PLANNING CONSULTATION RESPONSE

Application No	2026/0269
Proposal	Display of freestanding illuminated totem front sign. (Advertisement Consent)
Address	10 Wombwell Road, Platts Common, Barnsley, S74 9SQ
Date of Consultation Reply	24 th April 2026
Consultee	Highways DC

SITE PLAN
SCALE 1:500 AT A3

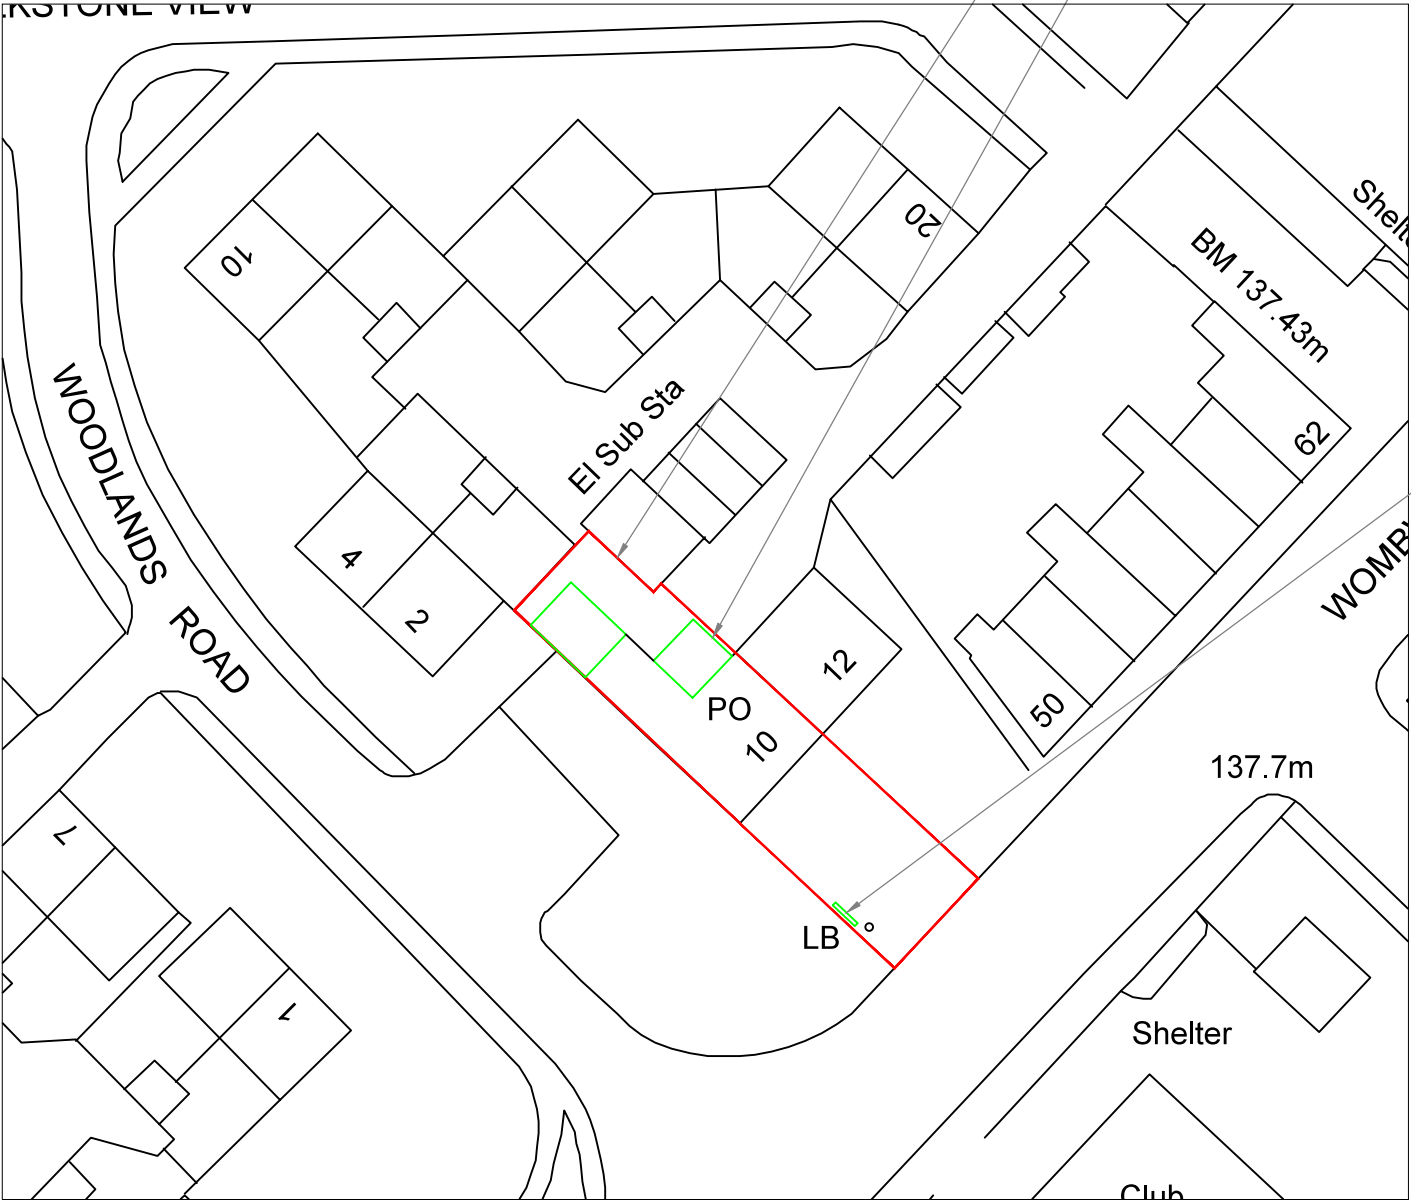
- Whether the significant increase in retail floor area would result in an increase in the number of employees.
- What impact the extensions would have on the parking/servicing arrangements to the rear of the store. For example, the image below shows a vehicle parked in the location of the proposed kitchen extension.

It should therefore be confirmed whether or not the proposals result in the loss of any off-street parking/servicing provision.

SIGN SIDE ELEVATIONS
SCALE 1:100 AT A3

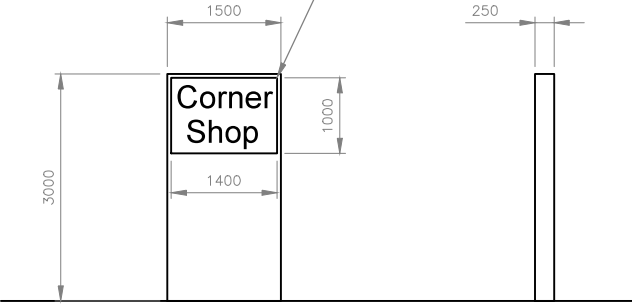
With regard to the proposed illuminated totem sign, it would be positioned back from the public highway and well above head height, as such, it is considered that it would not adversely impact upon any vehicular or pedestrian sight lines/visibility nor constitute an undue distraction to road users. The totem sign is to have a proposed maximum luminance of 300cd/m² which is within recommended maximum levels.

PROPOSED GROUND FLOOR PLAN  
SCALE 1:100 AT A3

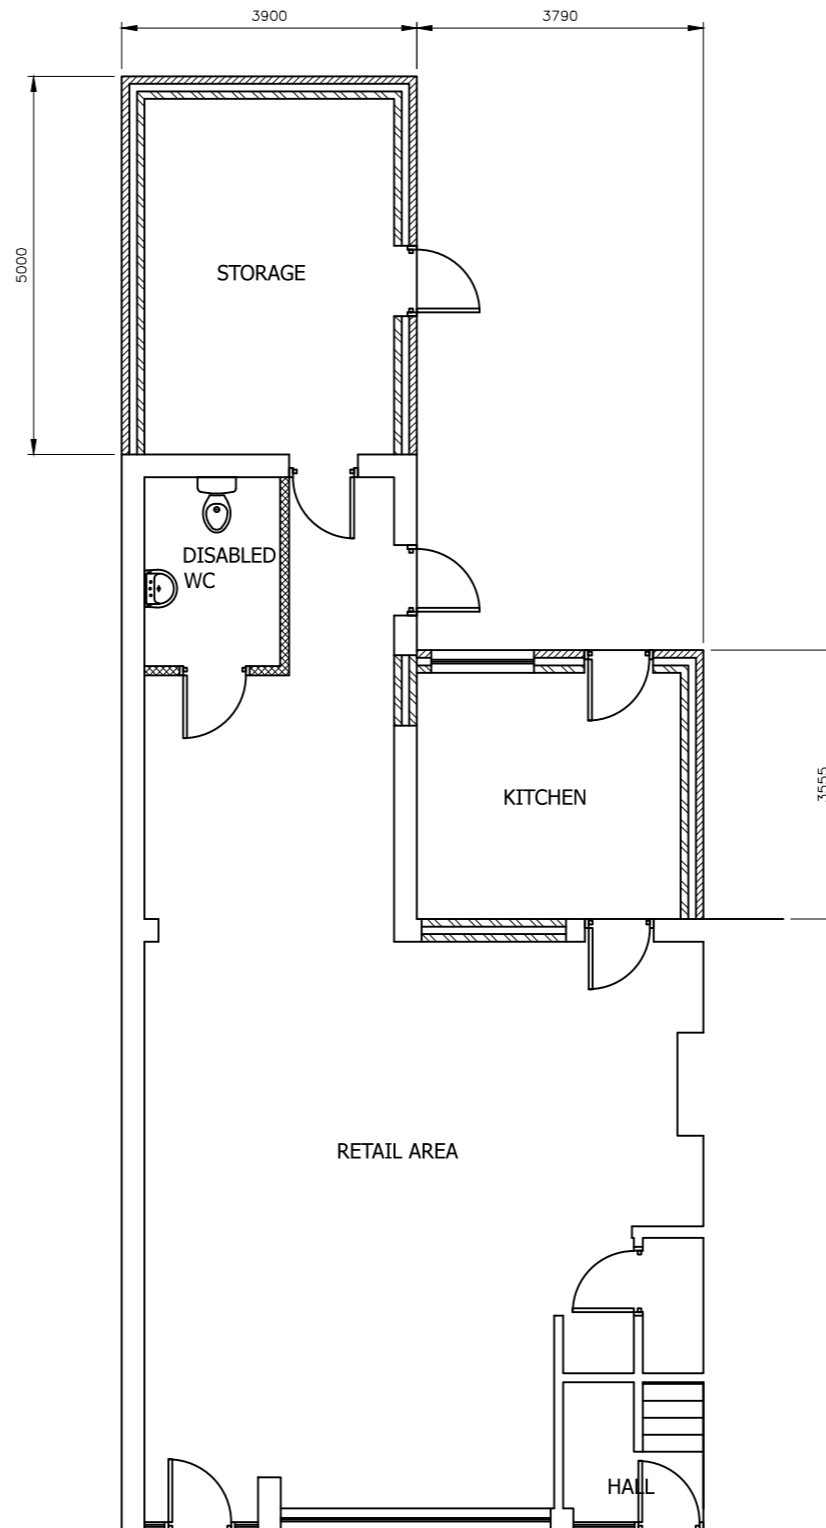
Along with the proposed illuminated totem sign, the proposals also comprise the erection of two rear extensions which would increase the floor area of the building by 29m².
